United Utilities Water PLC
Developer Services & Planning
Thirlmere House
Lingley Mere Business Park
Lingley Green Avenue
Great Sankey
Warrington WA5 3LP

Your ref: 3/2012/1049
Our ref: DC/12/5233
Date: 02-JAN-13

Location: Jones Stroud Insulations Queen Street Longridge Lancashire
Proposal: Erection purpose built storage and workshop building

SITE PLAN scale 1:500

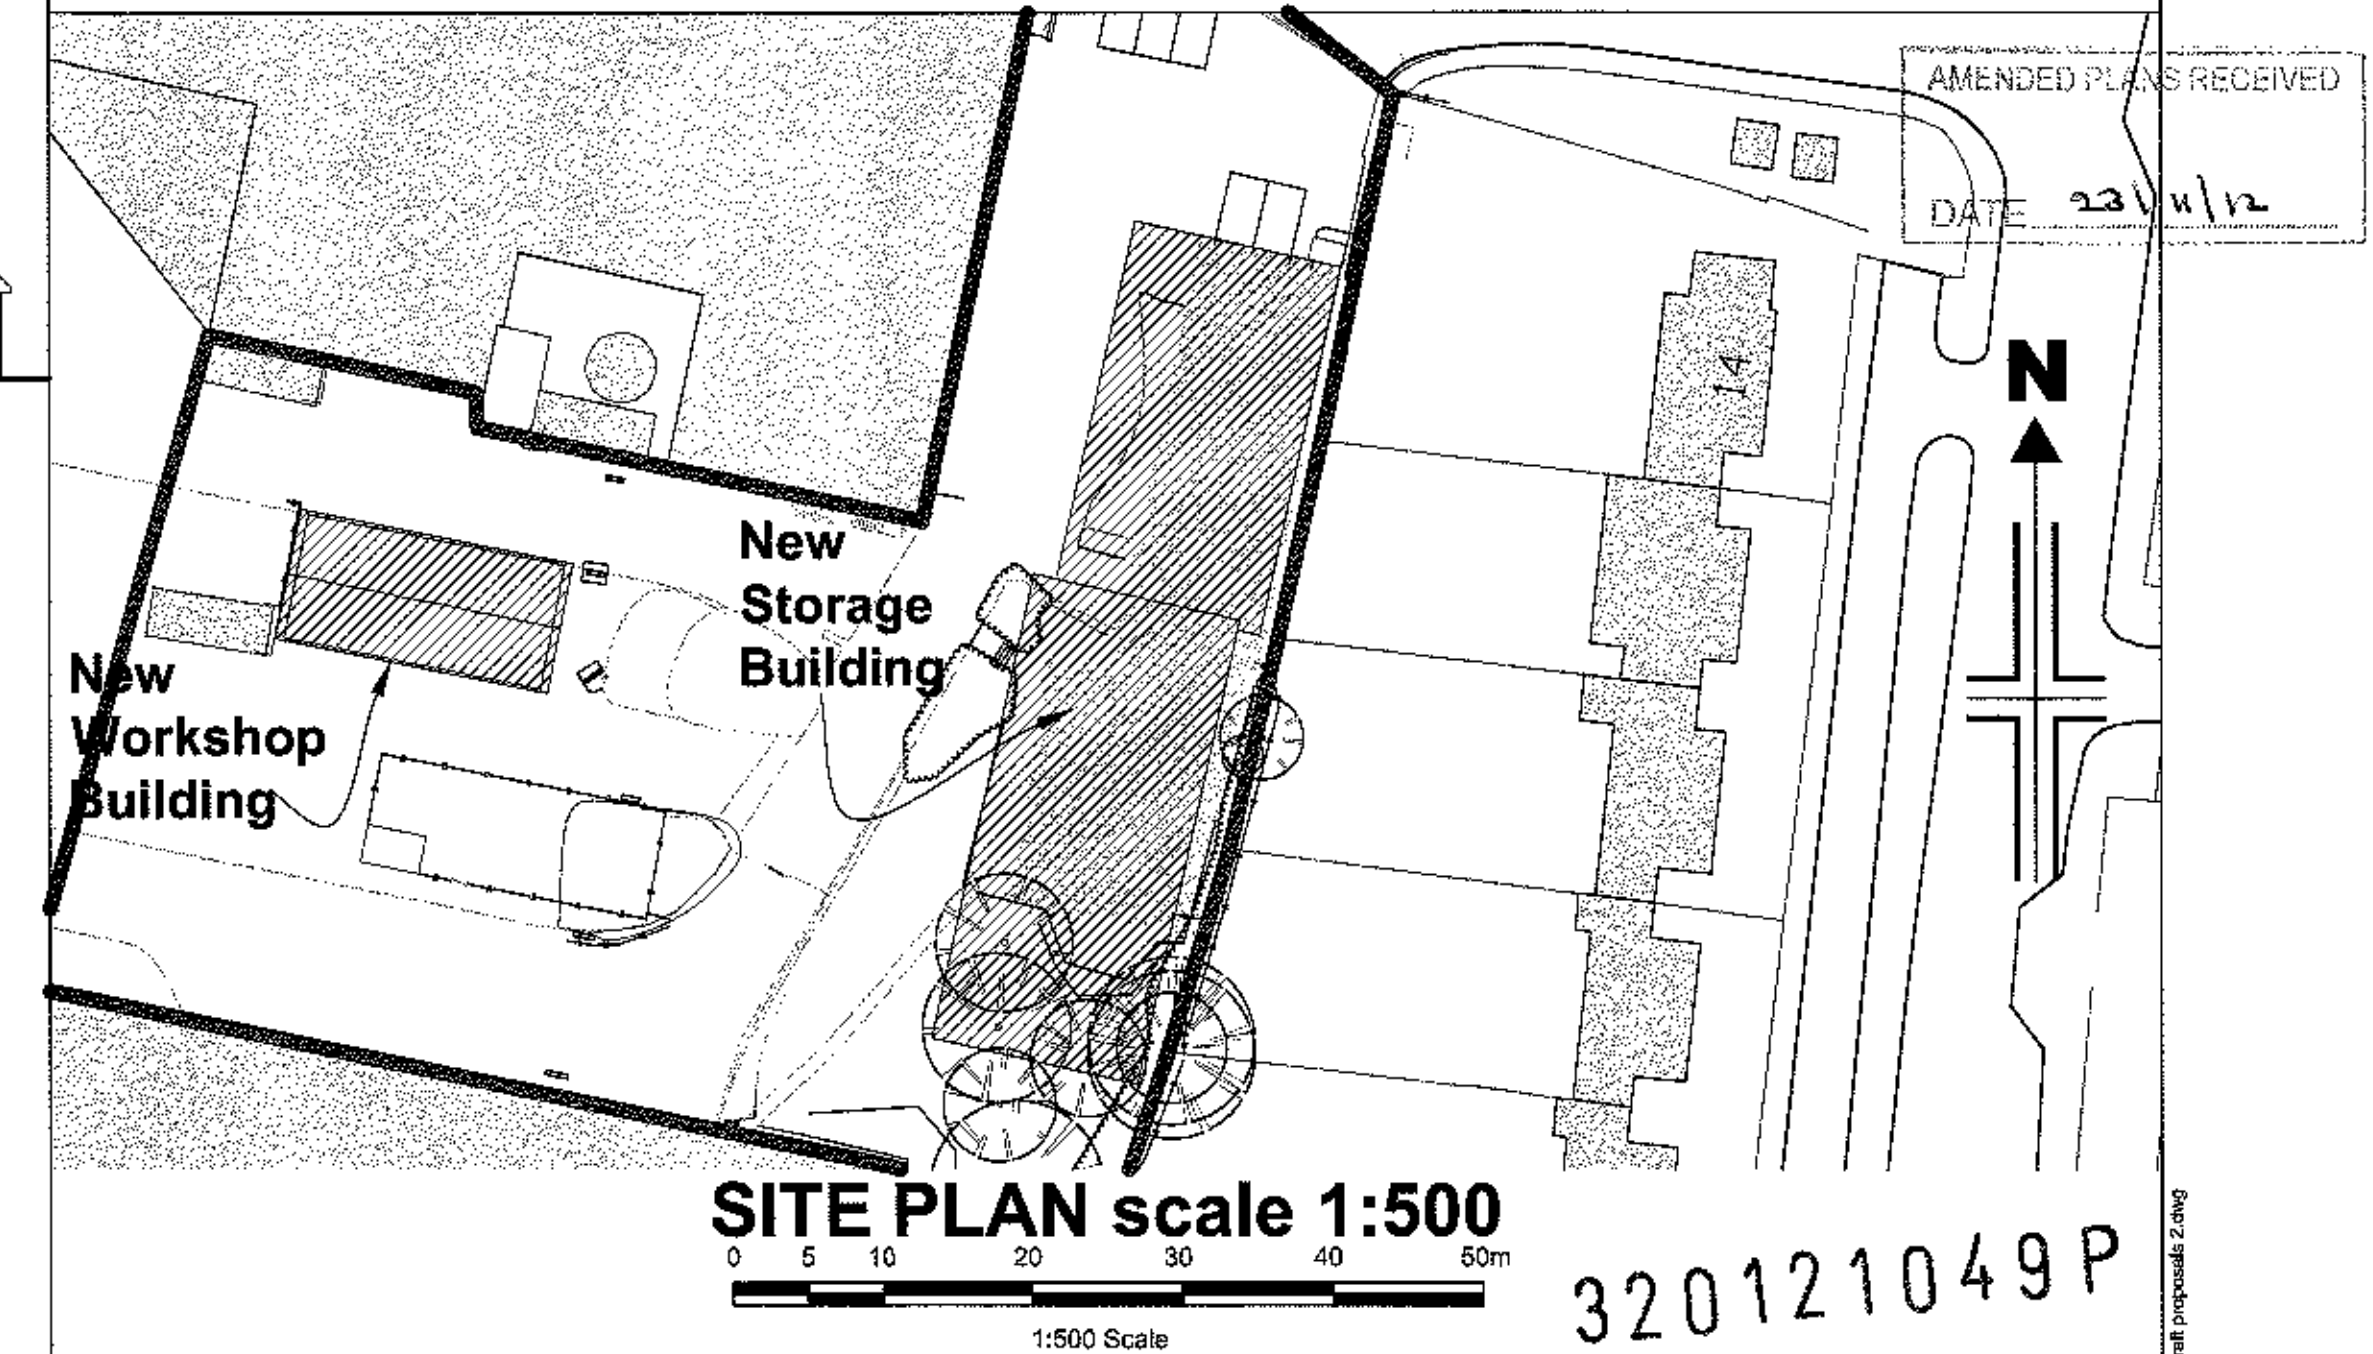
A public sewer crosses this site and we will not permit building over it. We will require an access strip width of 6 metres, 3 metres either side of the centre line of the sewer which is in accordance with the minimum distances specified in the current issue of "Sewers for Adoption", for maintenance or replacement.

A modification of the site layout, or a diversion of the affected public sewer at the applicant's expense, may be necessary. To establish if a sewer diversion is feasible, the applicant must discuss this at an early stage with Graham Perry the Developer Enquiries Analyst by email, planning.liaison@uuplc.co.uk as a lengthy lead in period may be required if a sewer diversion proves to be acceptable.

- Unless otherwise agreed in writing by the Local Planning Authority, no building shall be erected within 3 metres of any public sewer.
